November 1, 2019

**SUBJECT: Bent Grass Residential Filing No. 2 – Single Family  
Final Plat Application – Letter of Intent**

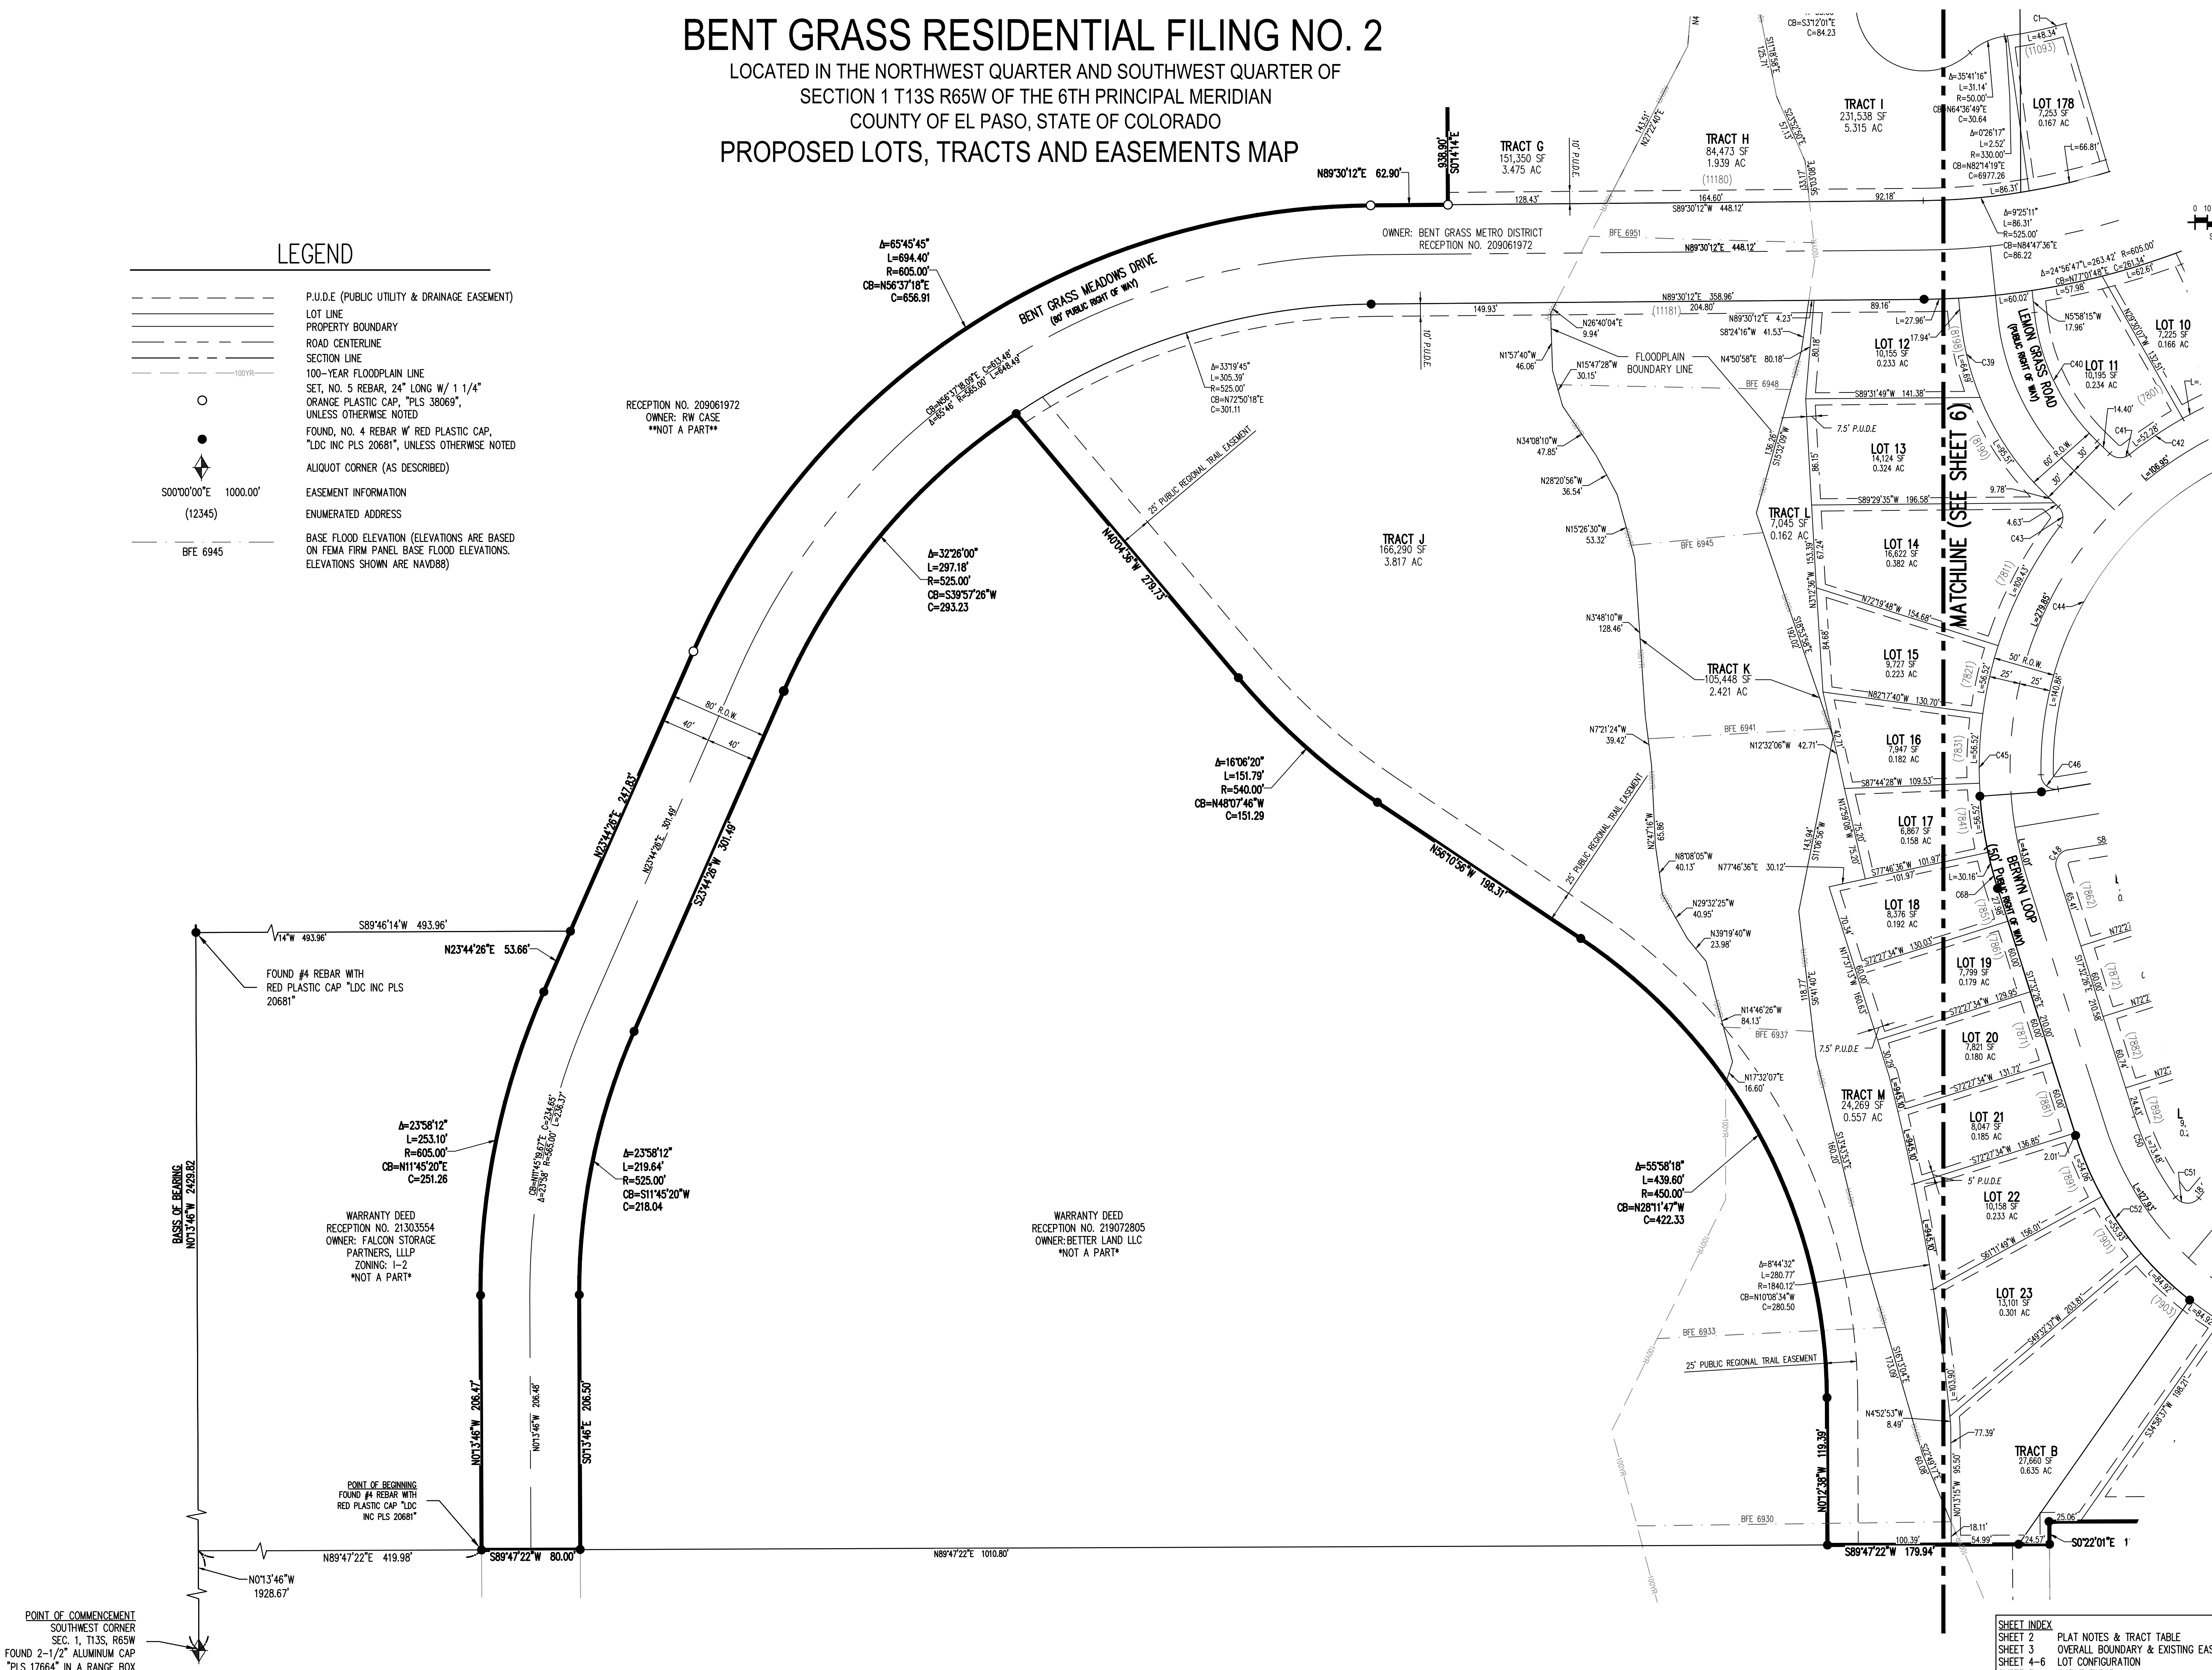
the plat is the time to  
plat these easements  
for trails...Challenger  
owns the land show  
the easments

Put the large  
drainage tract in this  
percentage - it is to  
be platted as a tract-  
not a future  
development tract  
platted, that is  
adjacent to the  
drainage tract

BENT GRASS RESIDENTIAL  
FILNG No. 2 PUD  
FINAL LANDSCAPE PLAN

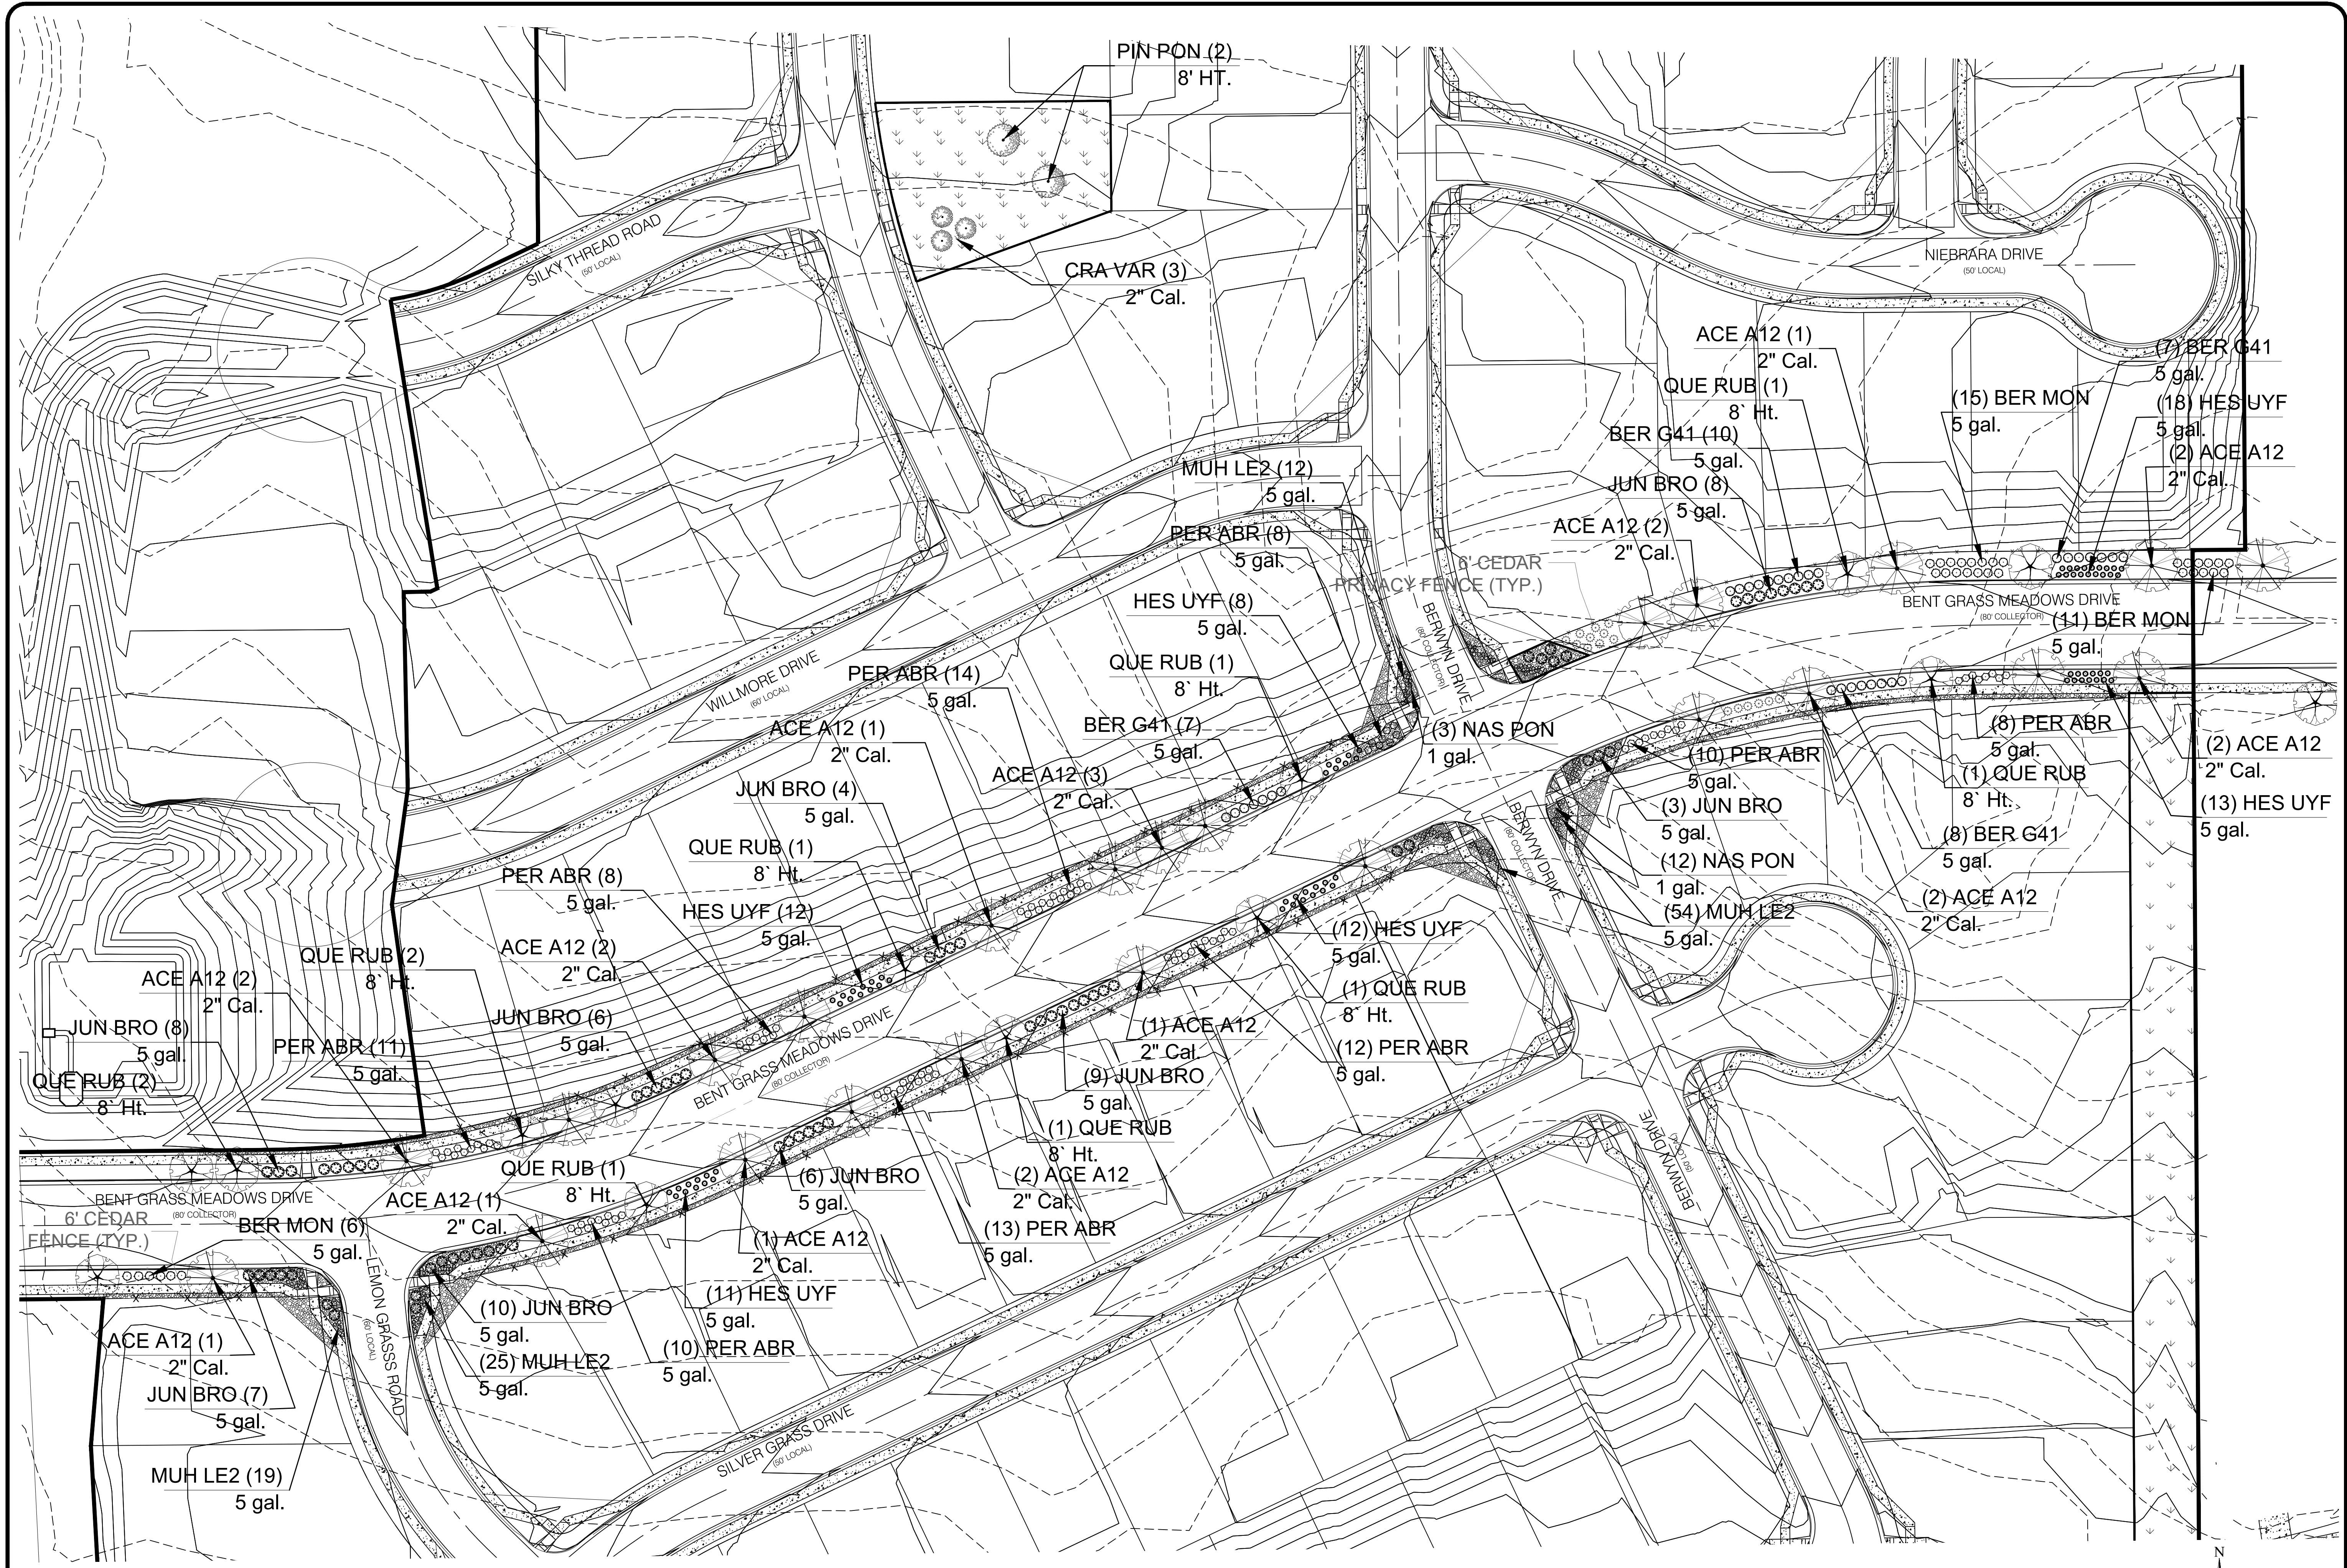
Bent Grass Meadows Drive?  
There are many double frontage  
lots-where is the landscape plan?
